28 January 2014

Our Ref: 140128PDASSDA4

Darling Harbour Live – The Haymarket Stage 2 Stage Significant Development Applications (SSDA 4) – Hyder Consulting response to City of Sydney recommendations, Transport for NSW letter and the Department of Planning and Infrastructure comments.

LEND LEASE DESIGN	THE HAYMARKET	DEVELOPMENT APPLICATION
	LEND LEASE DEVELOPMENT	SSDA4 - NORTH WEST PLOT COMMERCIAL CAR PARK LEVEL 1

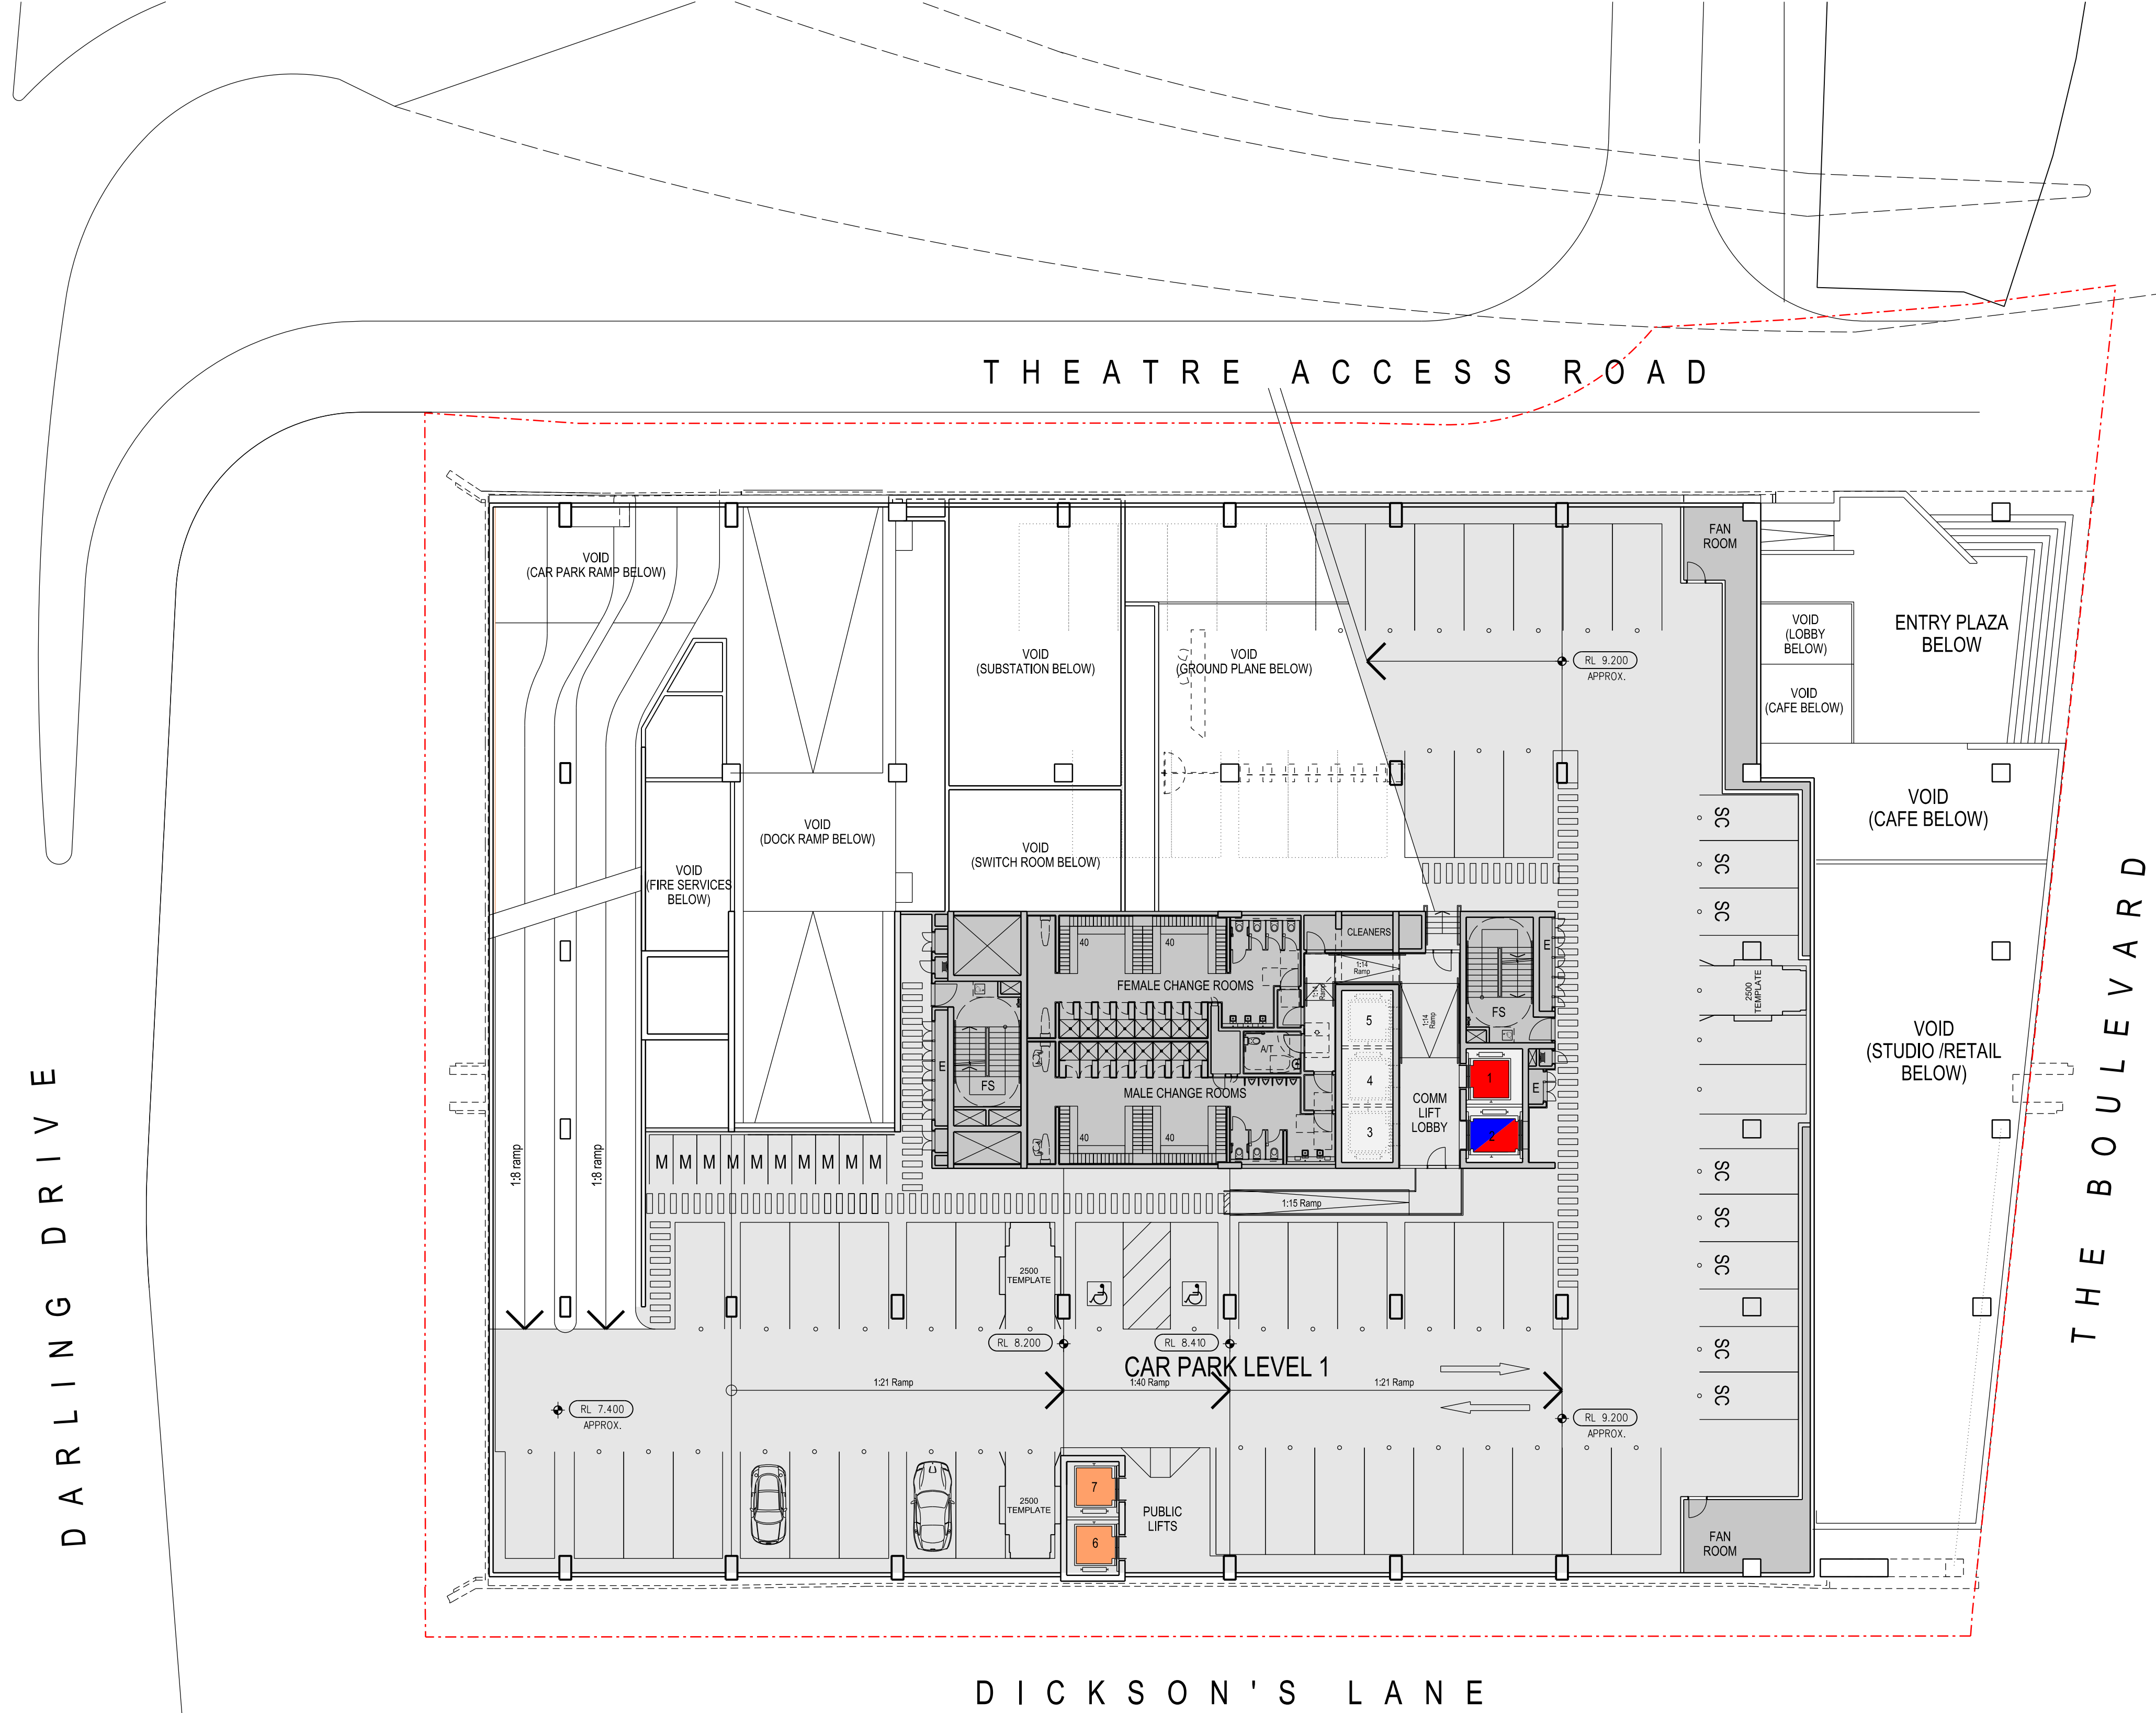
5. Consideration should be given to improving the access between the bicycle storage area and end of trip facilities, which are currently located on separate floors.	Architectural design changes to the building have located the bicycle parking and end of trip facilities on level P1 of the carpark. Access is provided via stairs with bicycle wheel ramps from the northern face of the building (similar to that proposed for the Barangaroo development) as well as internal access to the carpark, lifts and stairs

LEND LEASE DESIGN	THE HAYMARKET	DEVELOPMENT APPLICATION SSDA4 - NORTH WEST PLOT PUBLIC CAR PARK LEVEL 4A
	LEND LEASE DEVELOPMENT

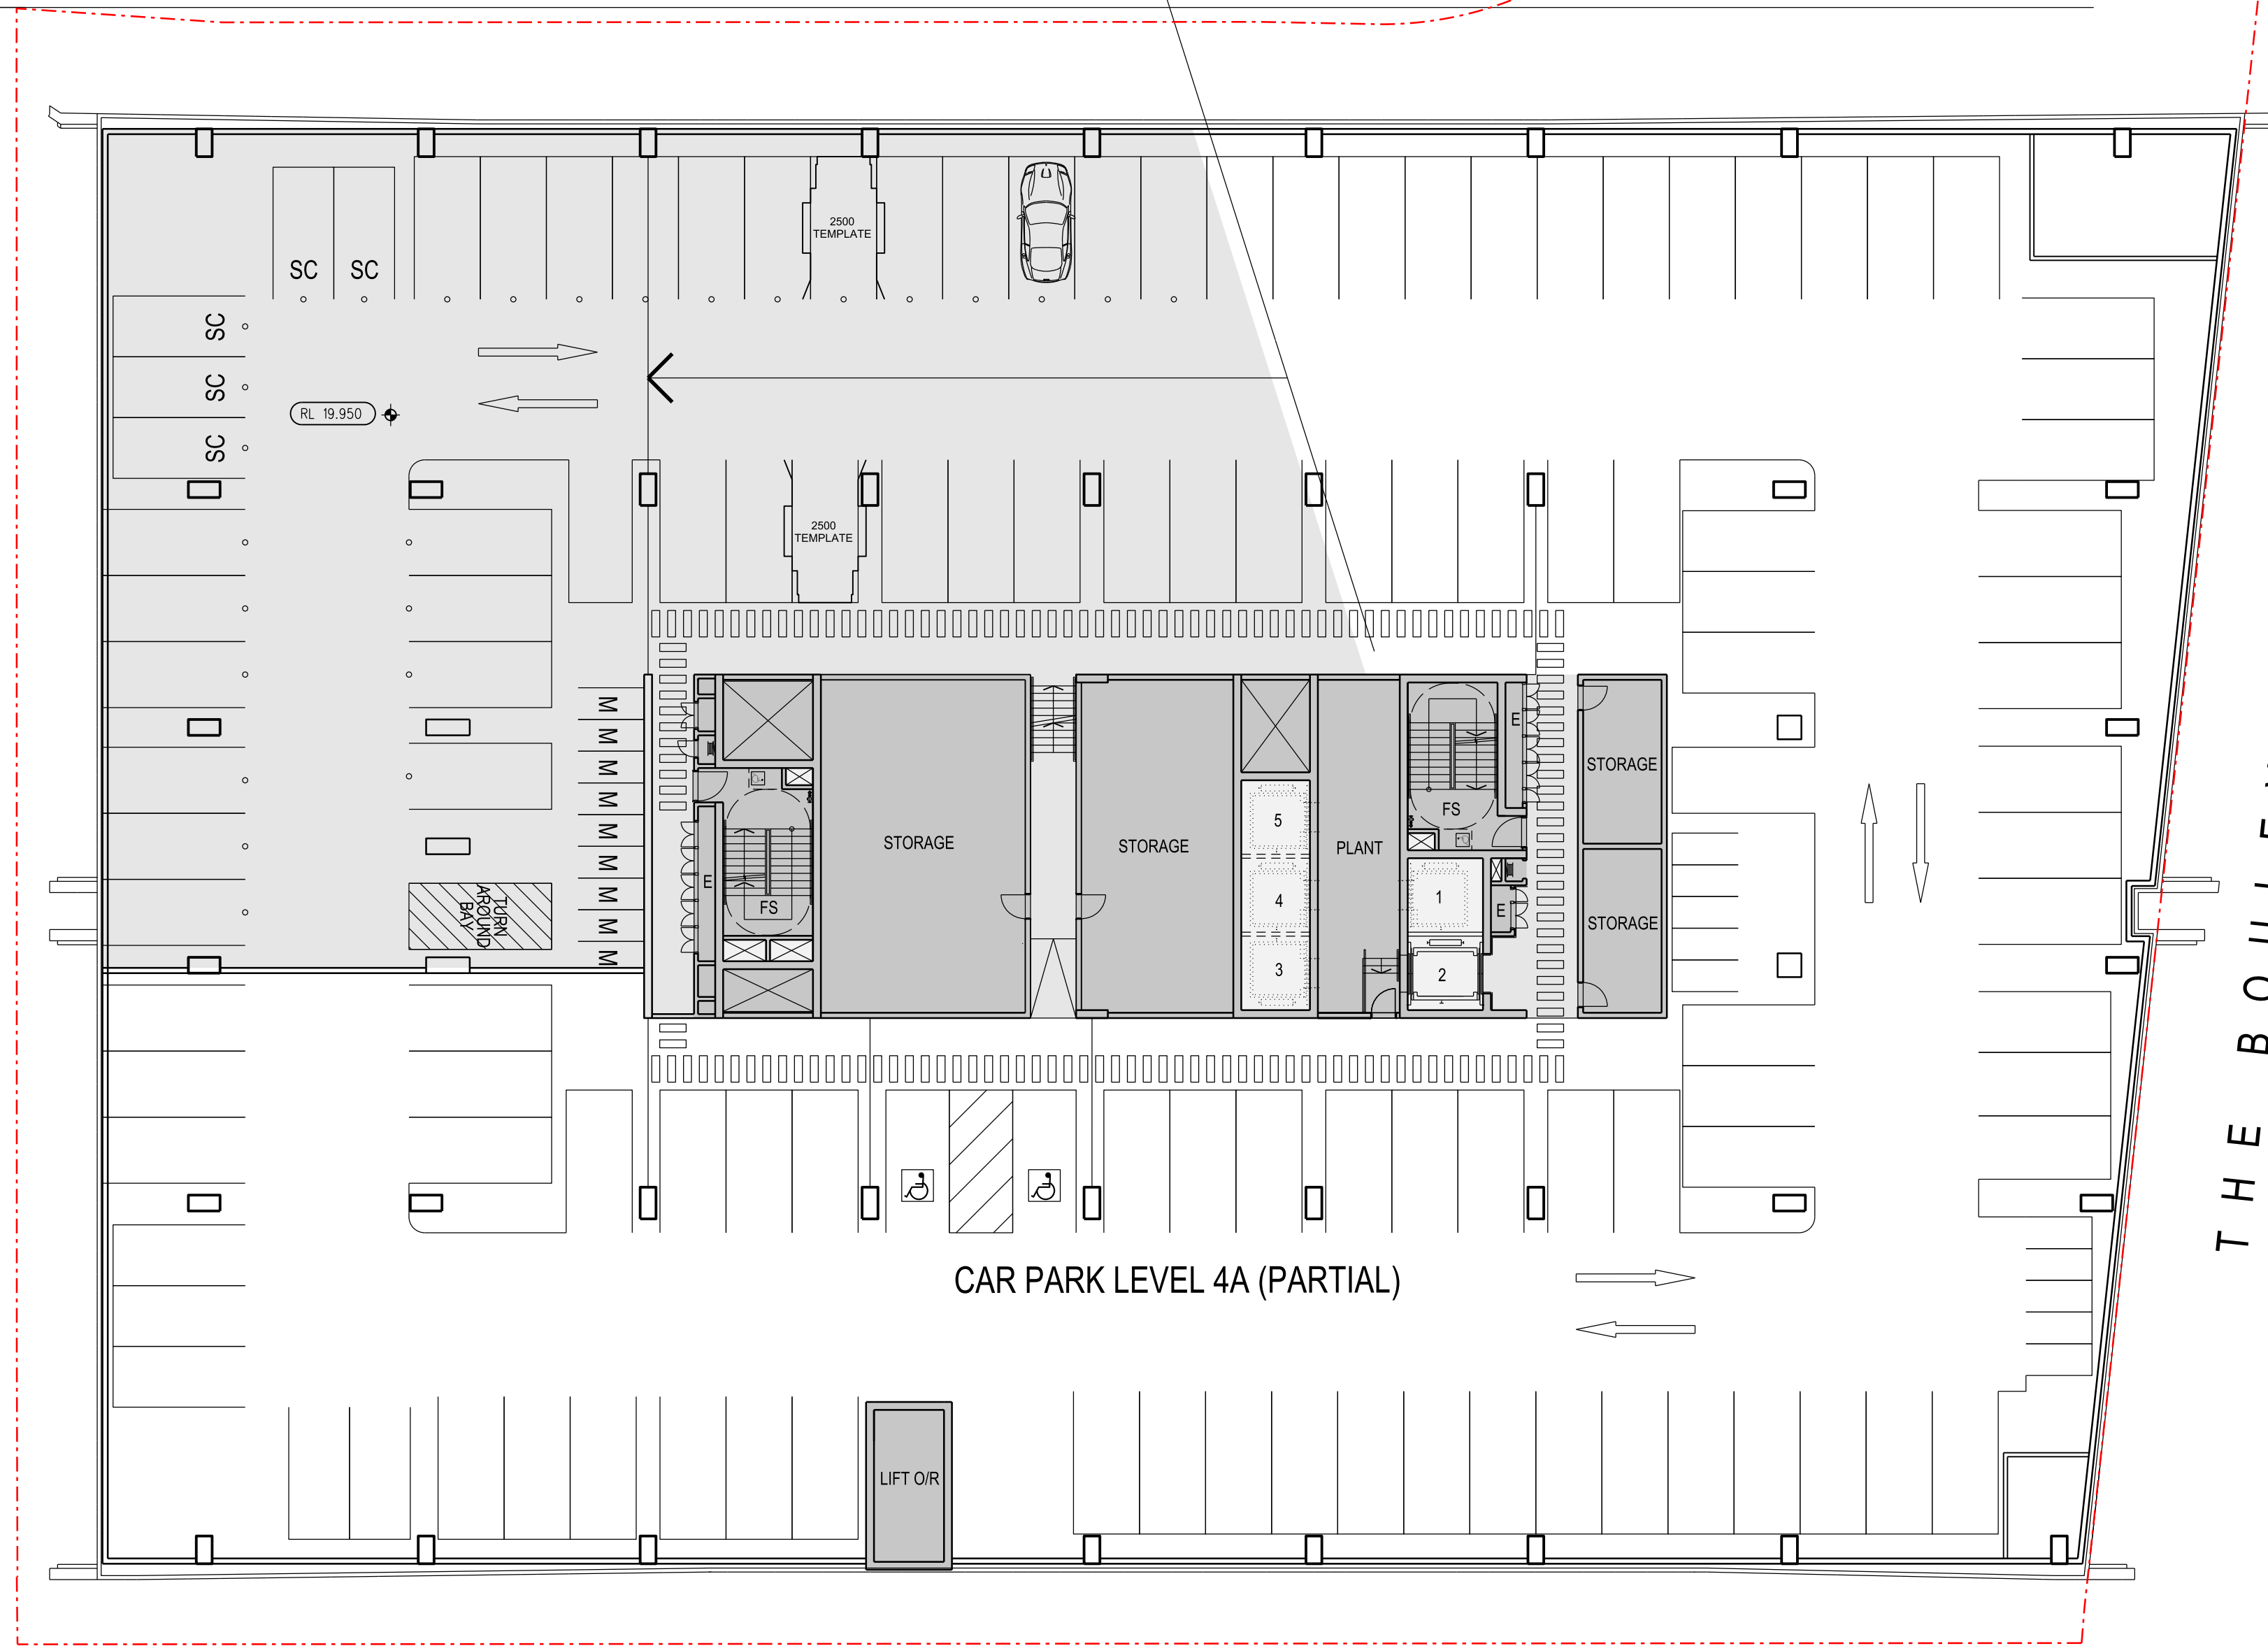
6. Consideration should be given to providing car-sharing space(s).	A car share space is provided on level 4a of the proposed carpark.
7. Justification is required for the level of motorcycle parking provision.	75 motorcycle parking spaces are proposed to be distributed across five levels of parking which exceeds the City of Sydney DCP 2012 requirement of 1 motorcycle parking space for every 50 spaces. These spaces utilise areas where a standard parking space cannot be located and building structure is not required, not possible or not desirable.
